Application: SSI 7485

I write regarding the proposed modification to M4-M5 Link, Mod 2 The Crescent overpass and changes to pedestrian infrastructure in North Annandale, Rozelle and Rozelle Bay Foreshore area.

Figure 4-2 Pedestrian and cyclist bridge infrastructure options

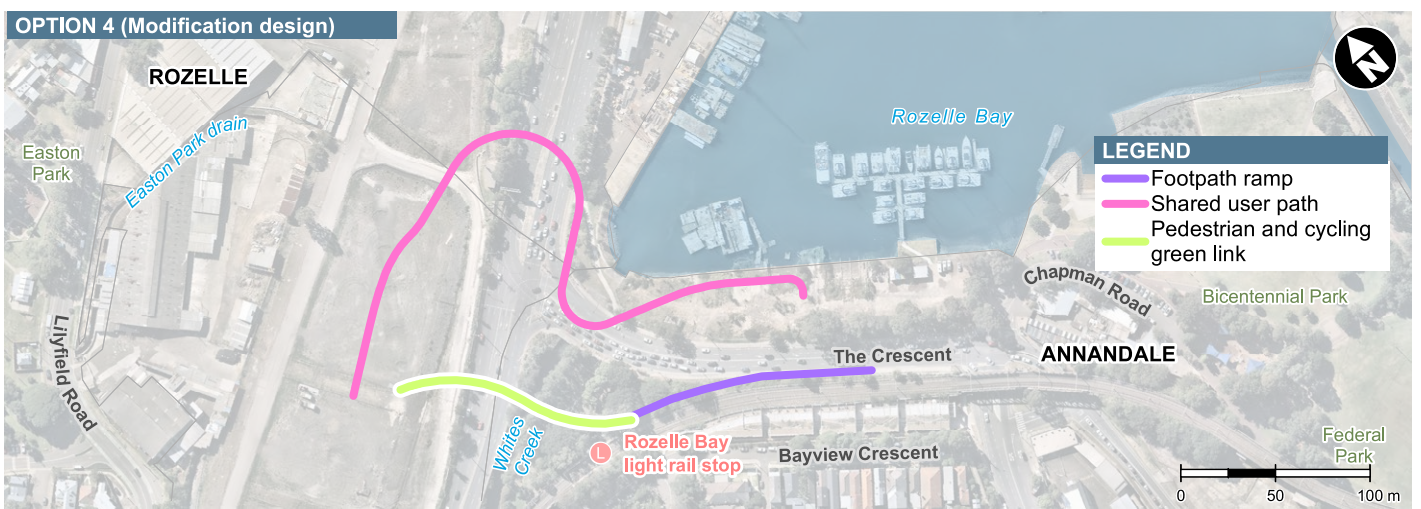
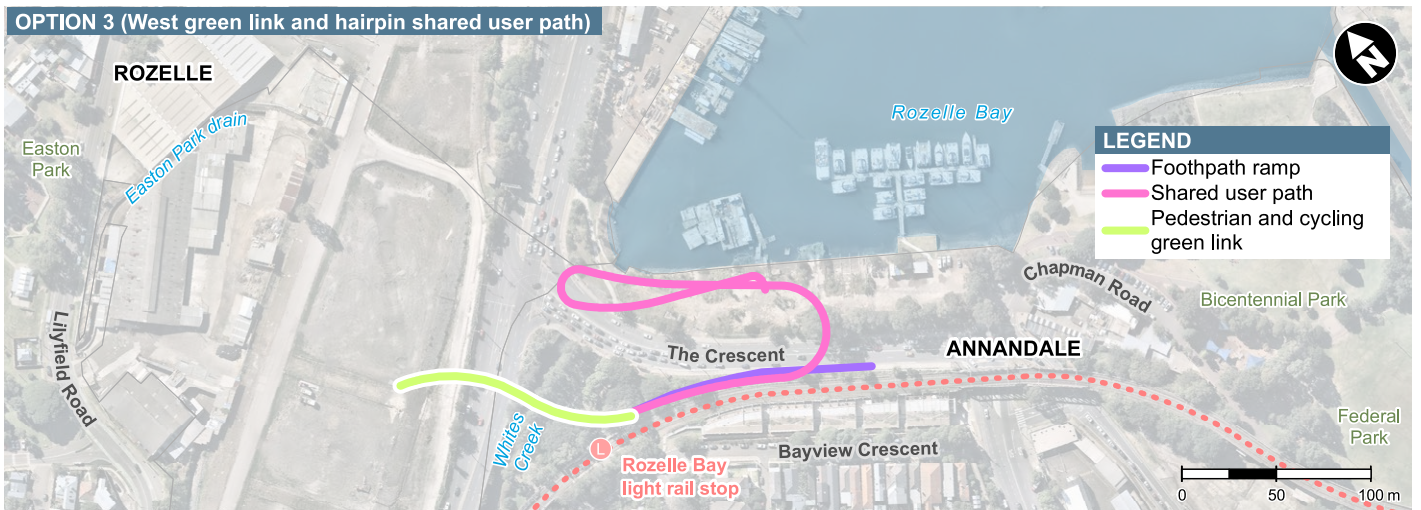
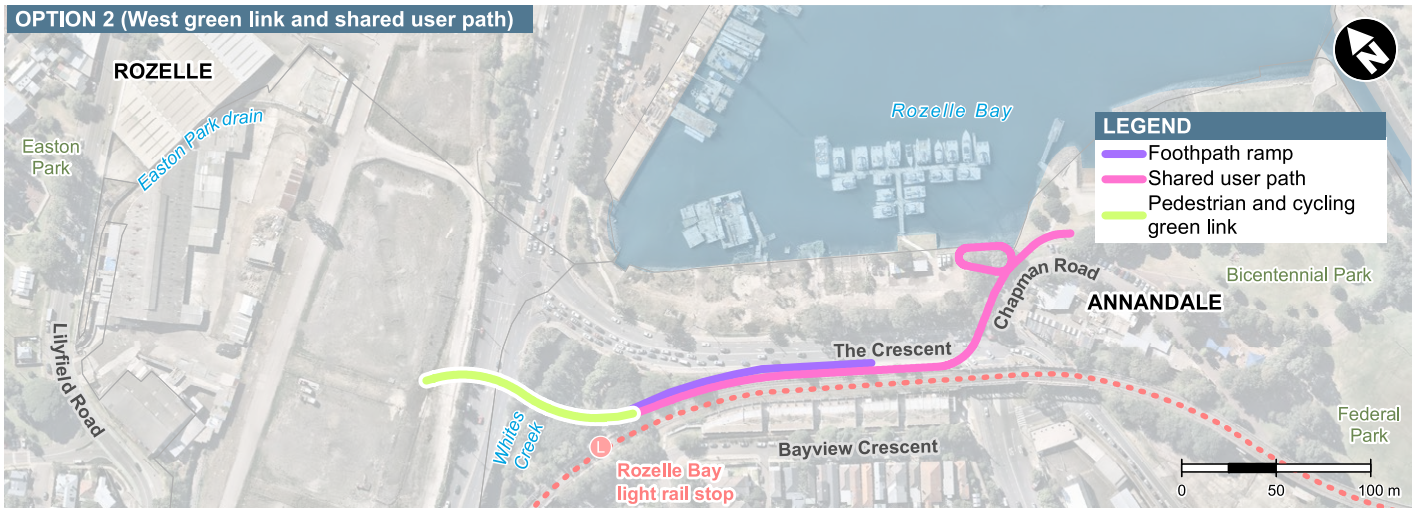
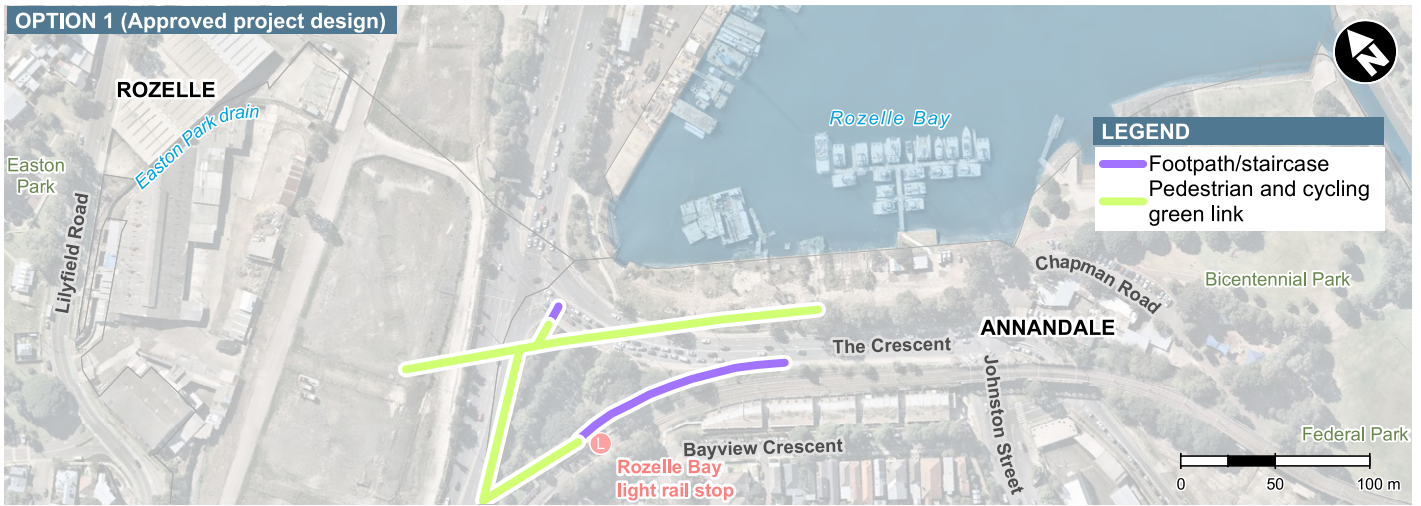
I request RMS work with the community to explore alternate design options to the proposed new car overpass design and the changed pedestrian and cyclist links. I am seeking the reinstatement of the safe, direct access from the approved EIS GreenLink to create a continuous green open space connection from the Rozelle Rail yards and Annandale to the foreshore. The GreenLink was more than just a walk way - it put people central to the design, maximising safety, and providing much needed accessible open space for the community now and into the future Bays Precinct design.

- The significantly reduced safety and increased risk for pedestrians and cyclists with removed access over The Crescent to Bicentennial Park and the increased traffic along Johnson Street.
- Being required to cross five sets of pedestrian lights at The Crescent as my option to reach the foreshore from Annandale or from Rozelle Bay light rail stop.
- Removal of direct active links to the foreshore, cutting the community off from the area and the proposed revitalisation of the entire Bays Precinct, including linking the Light Rail and Bus stops to a Ferry wharf and Metro station.
- Urban and landscape design that is being built before a finalised Masterplan for the area.
- Traffic changes that limit movements around the suburb and create further congestion in the local streets of Annandale, Forest Lodge, Glebe, Lilyfield and Rozelle with no planning to deal with these.

- Reinstate the GreenLink connecting communities and green open space from Rozelle to Bicentennial Park
- Relocate and design pedestrian and cyclist connections that are continuous, safe and direct.
- Design the modification infrastructure and active links in response to the character of the suburbs, the location of the foreshore and it's potential future development.
- Provide pedestrian and cyclist paths that maximise people safety and do not force them onto busier streets, unsafe concrete plazas and caged walkways.
- Integrate active and direct connections to all active transport – including the future Metro West and Foreshore Ferry Wharf

Figure 4-4 Elevation: Indicative view of The Crescent overpass

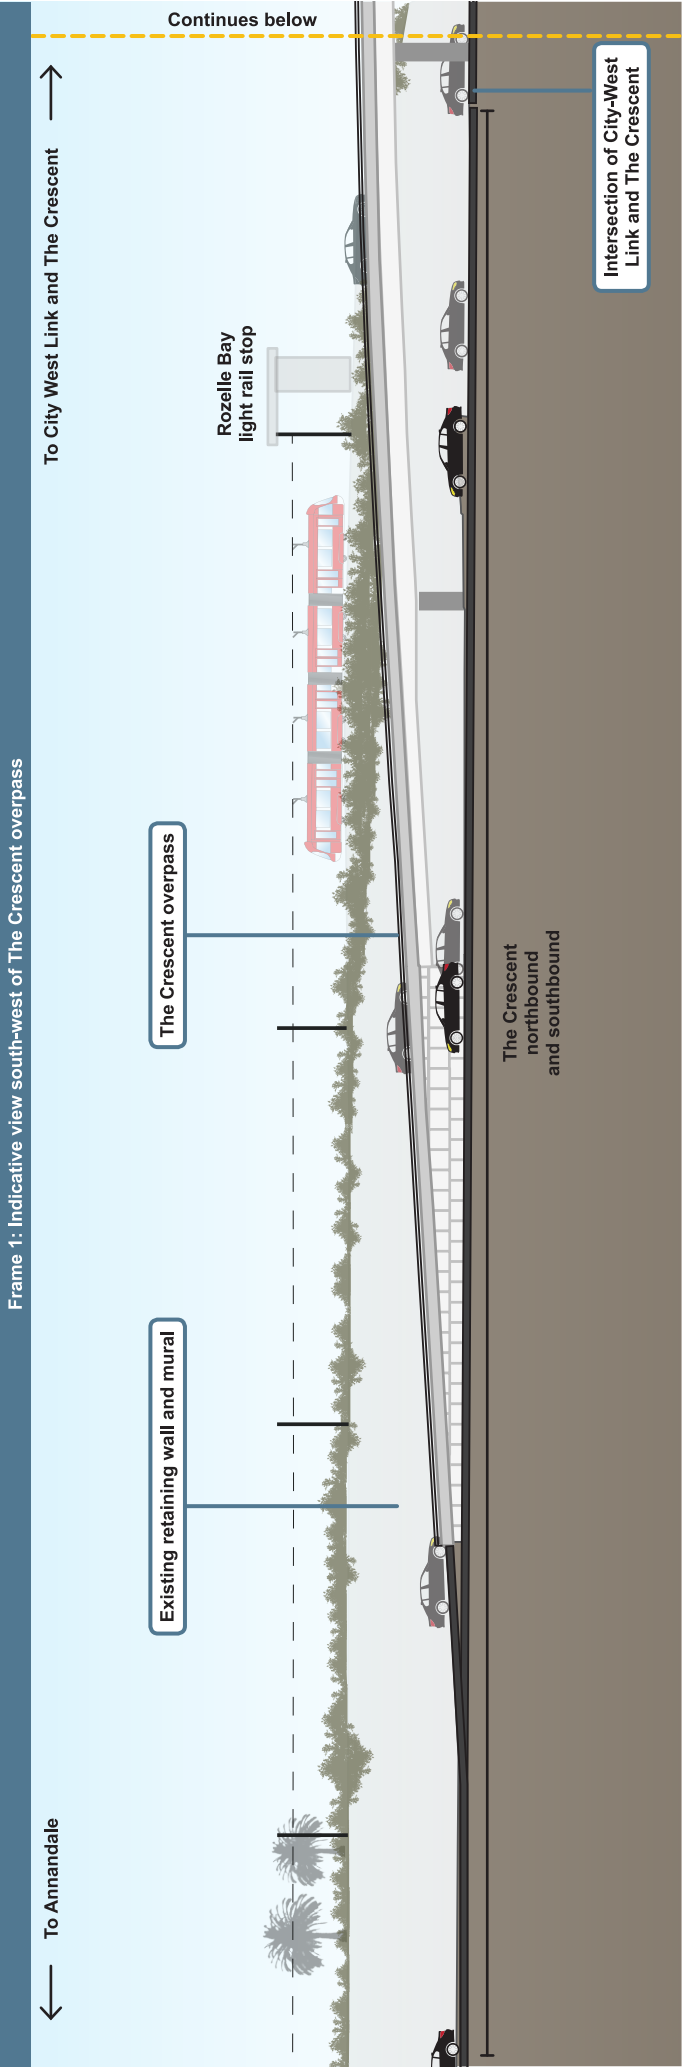
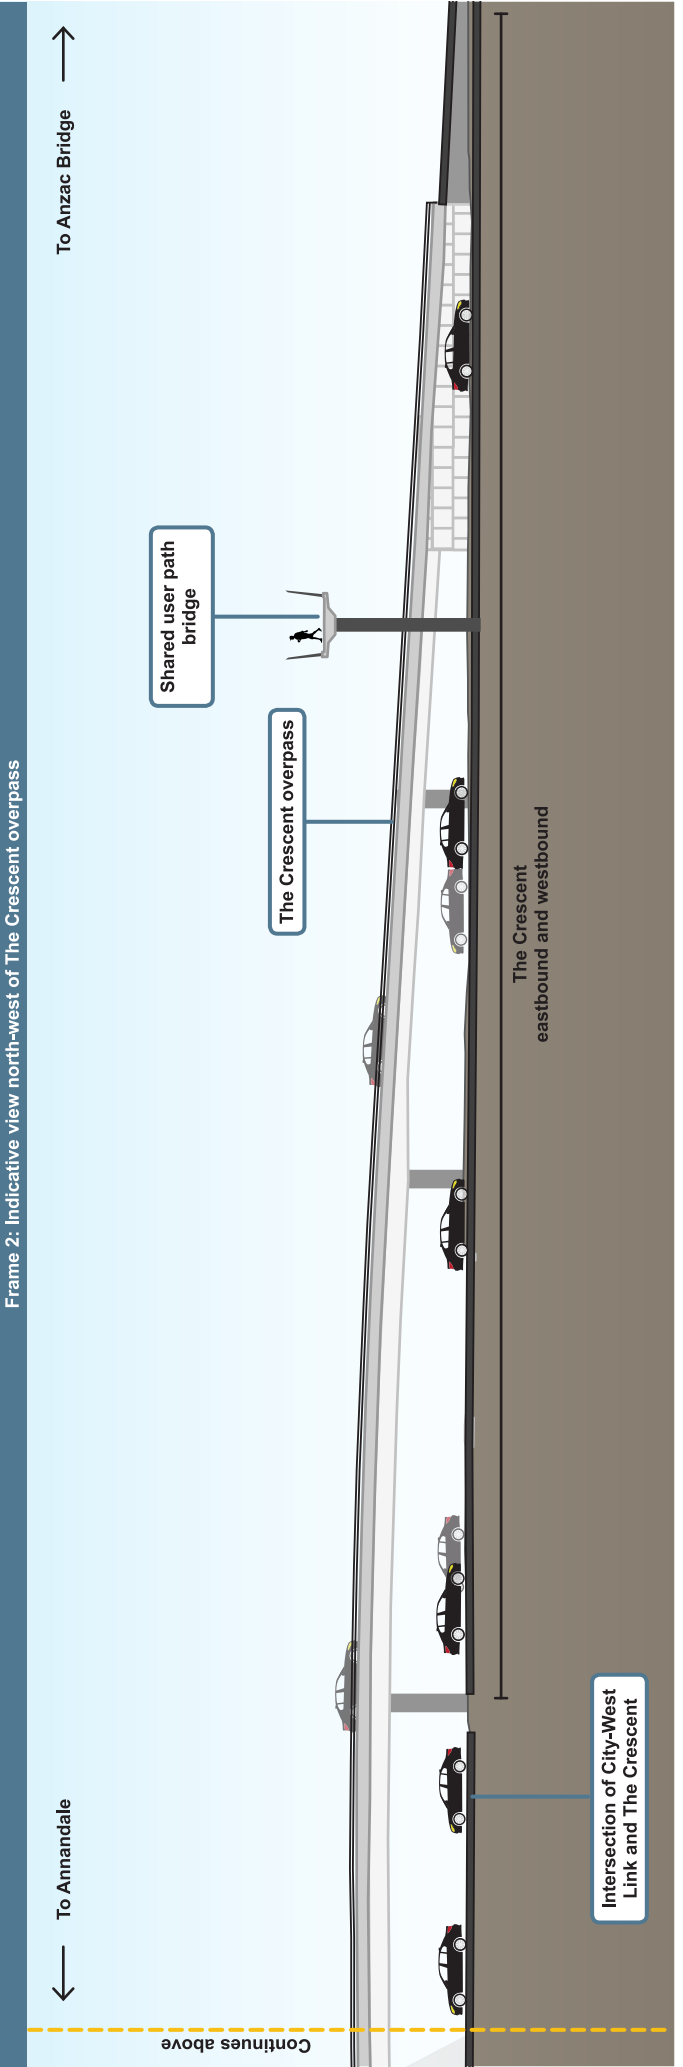
New M4-M5 Link MOD 2 creates a horrible eye-saw. Concrete overpass that ruins the look of Rozelle Bay precinct and makes a mockery of intention to beautify 'Greenlink' Rozelle Bay, Fish markets etc. Will also create a speedway onto the Anzac Bridge.
